Appeal Decision

Appeal Ref: APP/R5510/D/24/3358175

106 Torrington Road, Ruislip HA4 0AU

- The appeal is made under section 78 of the Town and Country Planning Act 1990 (as amended) against a refusal to grant planning permission.
- The appeal is made by Anil Parmar against the decision of the Council of the London Borough of Hillingdon.
- The application Ref is 28633/APP/2024/2601.
- The development proposed is described as 'Rear garden annexe to provide extra garden and pantry storage and entertainment space'.

| SHEET   | Rear Annexe - Section |

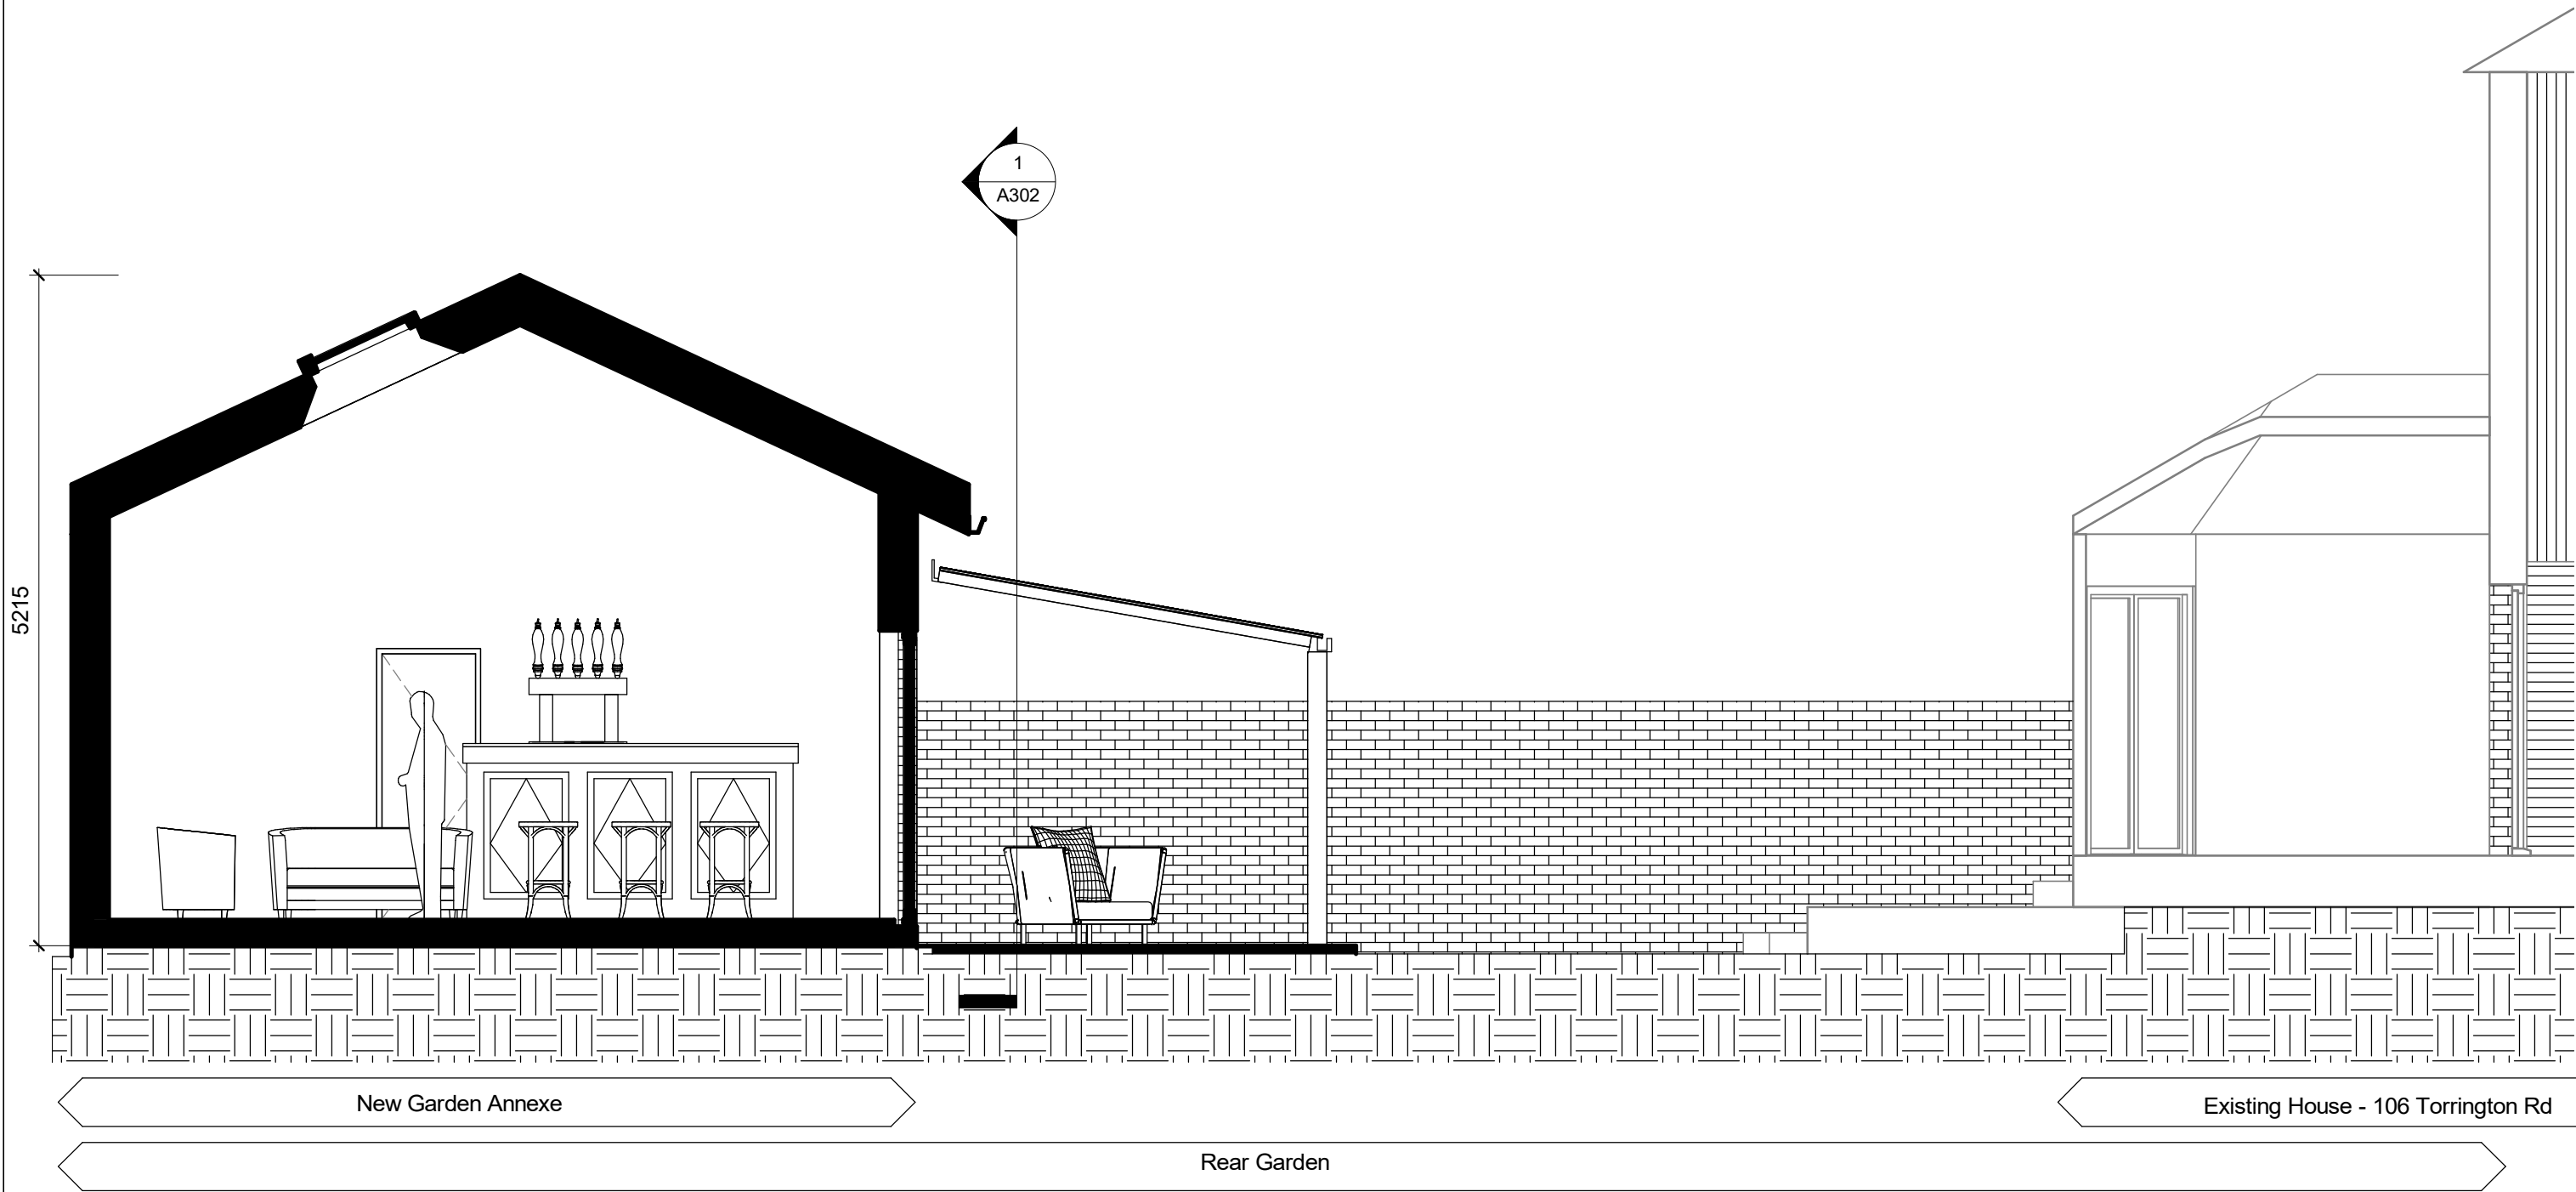
5. The evidence before me indicates that the internal floor space of the outbuilding would be 48sq m. The supporting text to Policy DMHD 2 Hillingdon Local Plan Part 2 – Development Management Policies (January 2020) (LPP2) indicates that outbuildings should be no greater than 30 square metres. While I accept that this figure is a general guide, when combined with its height, substantial pitched roof

and lean-to canopy, the outbuilding would not appear proportionate to the host dwelling. Even accounting for the use of high quality materials, this would not be sufficient to assimilate the outbuilding's substantial bulk and mass which would have undue dominance within the rear garden environment. Due to its height significantly above boundary fencing and walls, and even accounting for vegetation in gardens, the proposal would be unduly prominent when experienced from the nearest neighbouring windows and gardens.

**1** Front Elevation

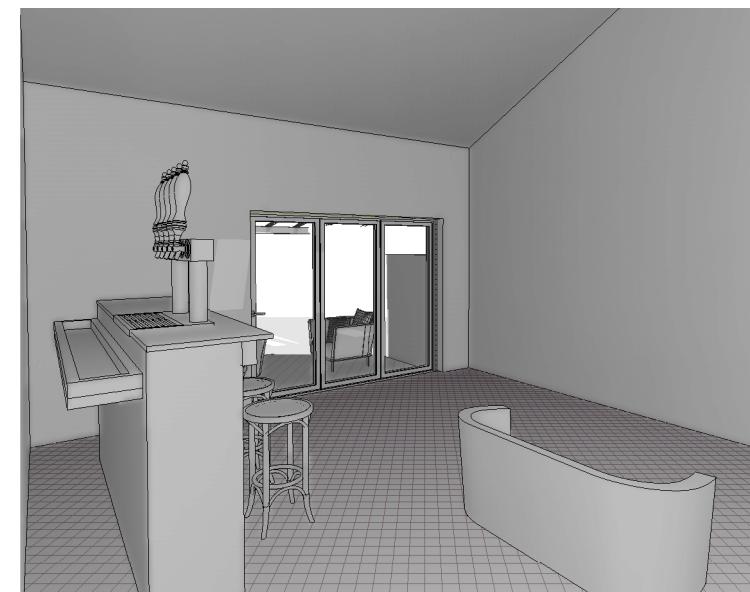
6. From visiting the site, I acknowledge that large outbuildings are a common feature in the area. These range in terms of form and materials and many also extend the full width of the plots they sit within. However, the outbuildings are more often low in height with shallow pitched or flat roofs, particularly in the more immediate surroundings of the appeal site. This means that they generally have a discreet presence within their respective plots and when experienced from neighbouring properties. Therefore, they are not comparable to the more dominant form of the appeal proposal.
